**HELIOS** RENEWABLE  
ENERGY  
PROJECT

**PINS Document Number:**  
EN010140/APP/8.8

# **The Applicant's Response to North Yorkshire Council's Local Impact Report**

Planning Inspectorate Reference: EN010140

Environmental Statement Figure 7.19: Landscape Strategy Plan (Overall)

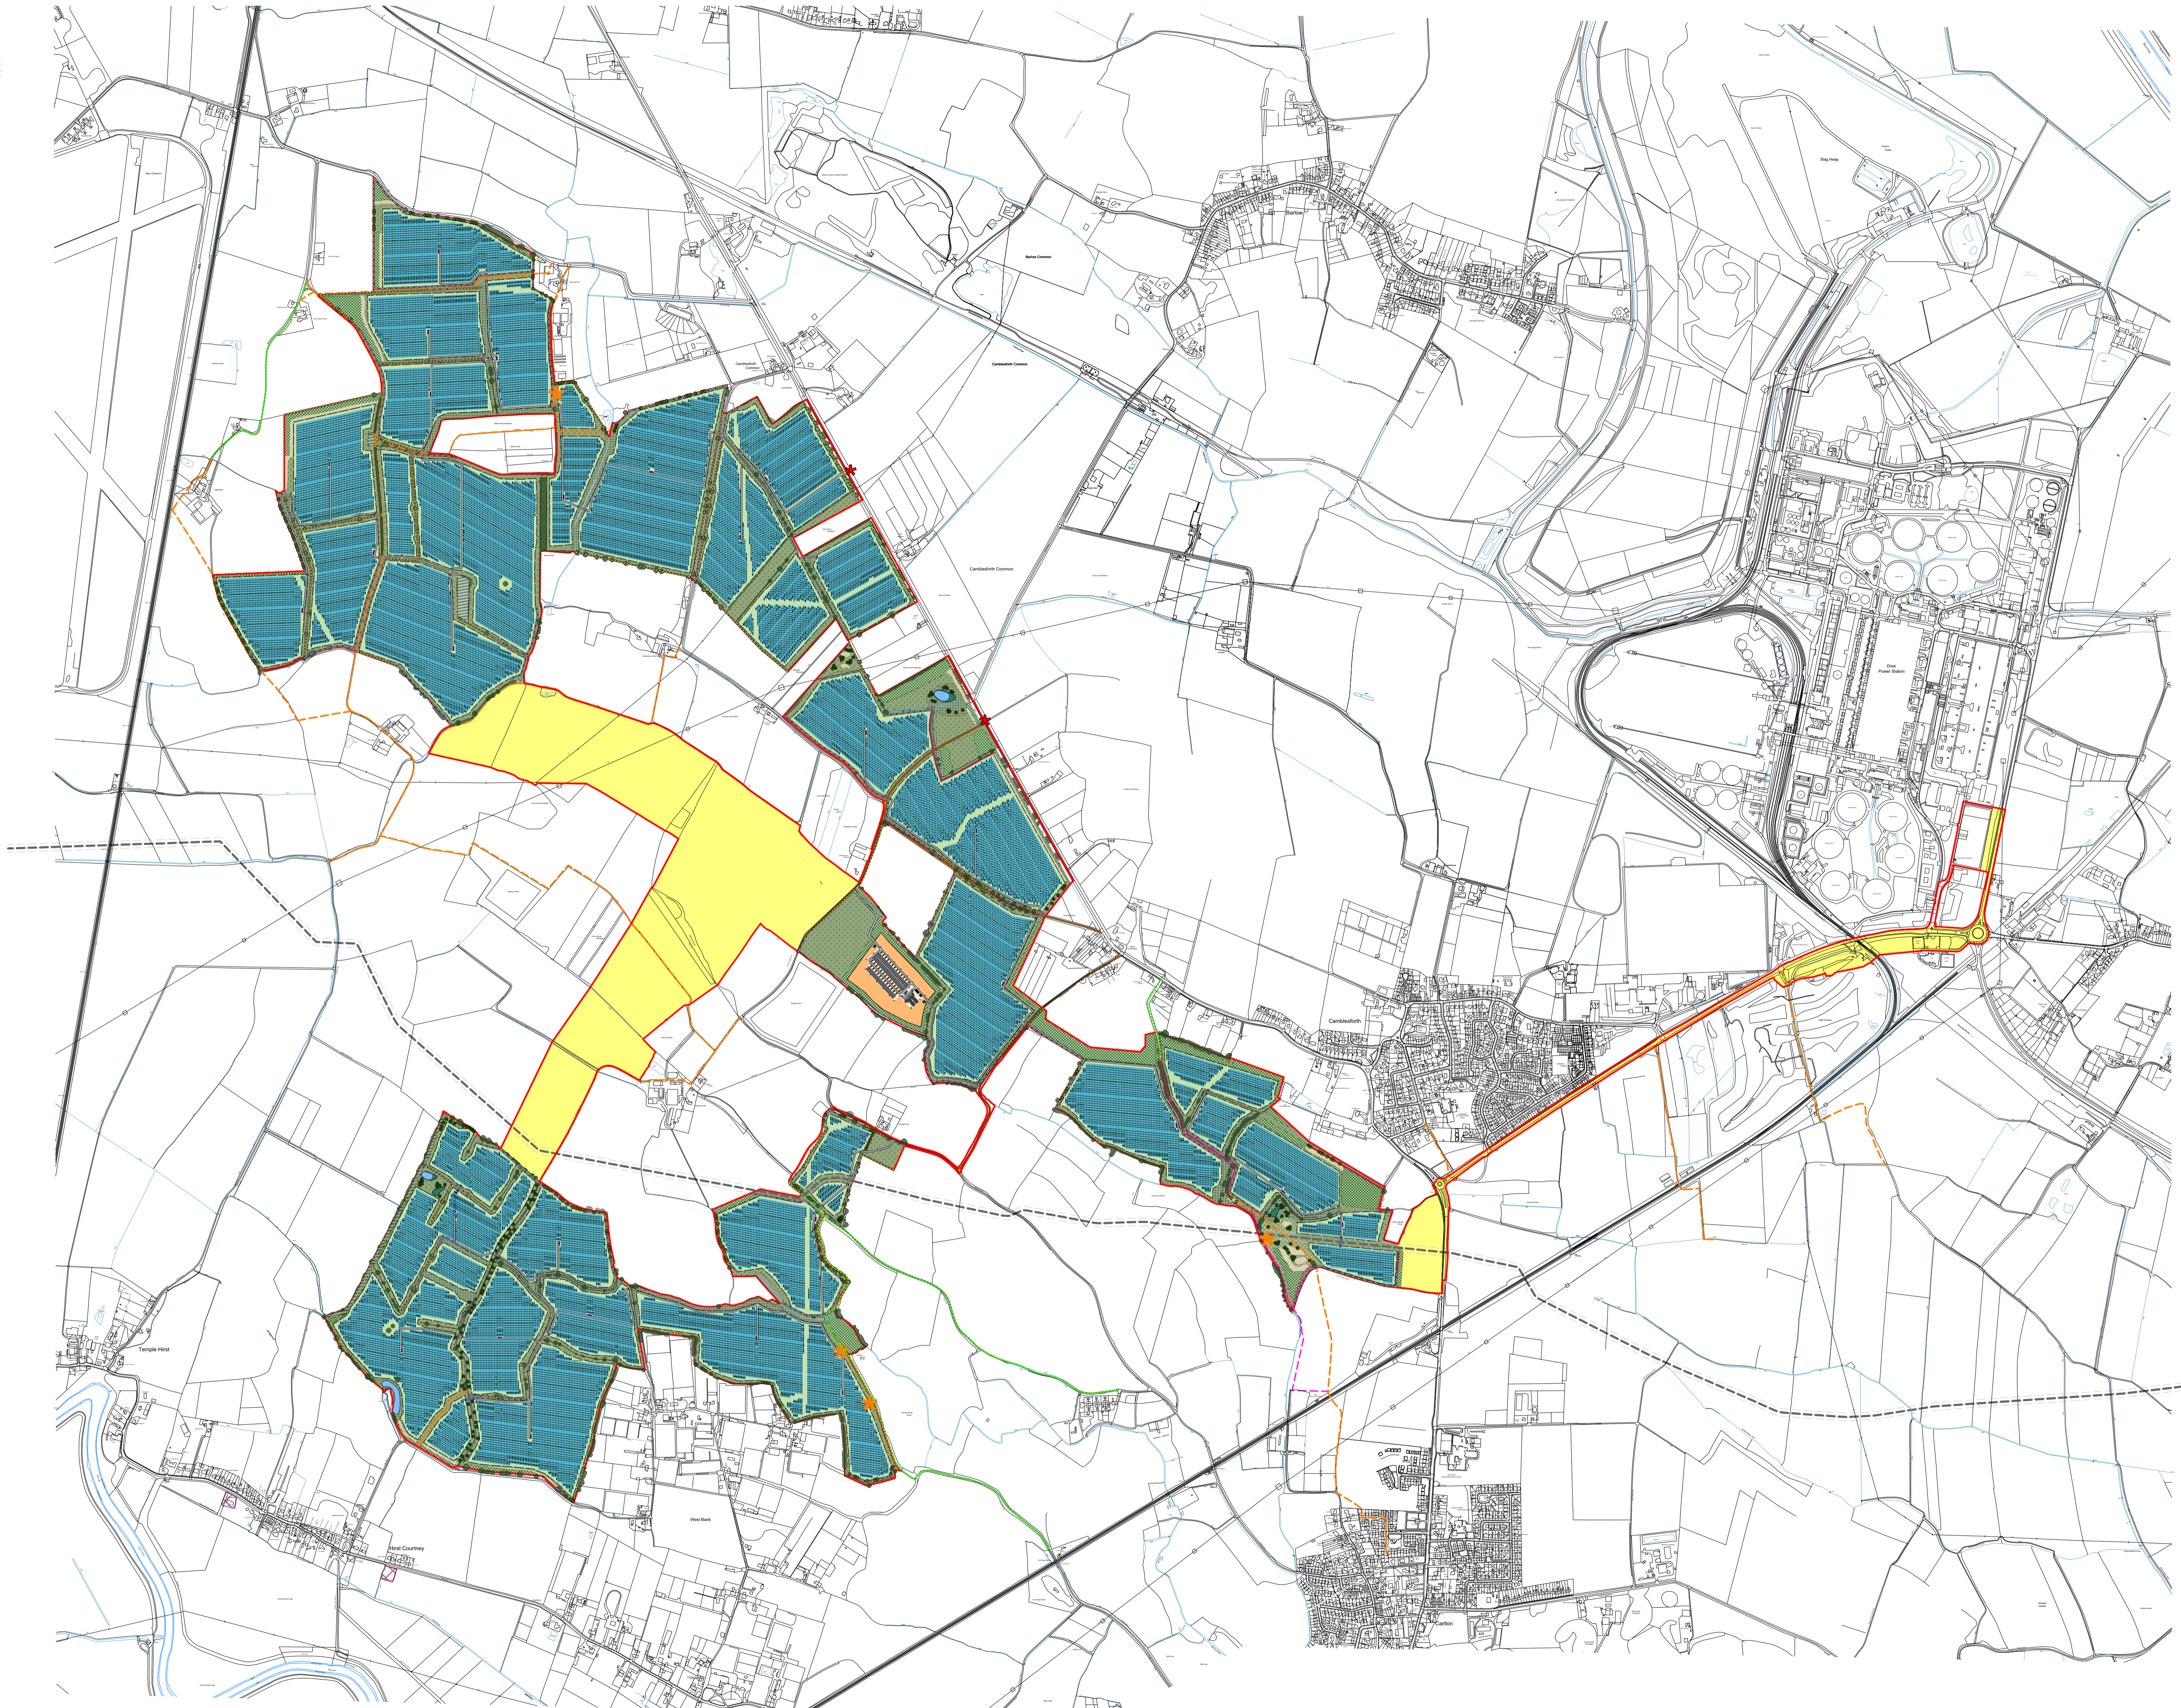
Landscape and Visual	<b>8.55 – 8.56</b>	<p><i>Adequacy of Mitigation</i></p> <p>Landscape mitigation at a wider strategic scale and to resolve cumulative effects is insufficiently considered. Additionally, there is no reference to Natural England's Green Infrastructure Framework within the application used</p>	<p>The landscape strategy <b>[APP-071 to APP-074]</b> for the Proposed Development incorporated principles set out in Natural England's Green Infrastructure Framework. The Applicant has also engaged in consultation with NYC and made alterations to the Proposed Development in response to comments received. The verbal feedback we received at the most recent meeting with NYC. During this meeting</p>
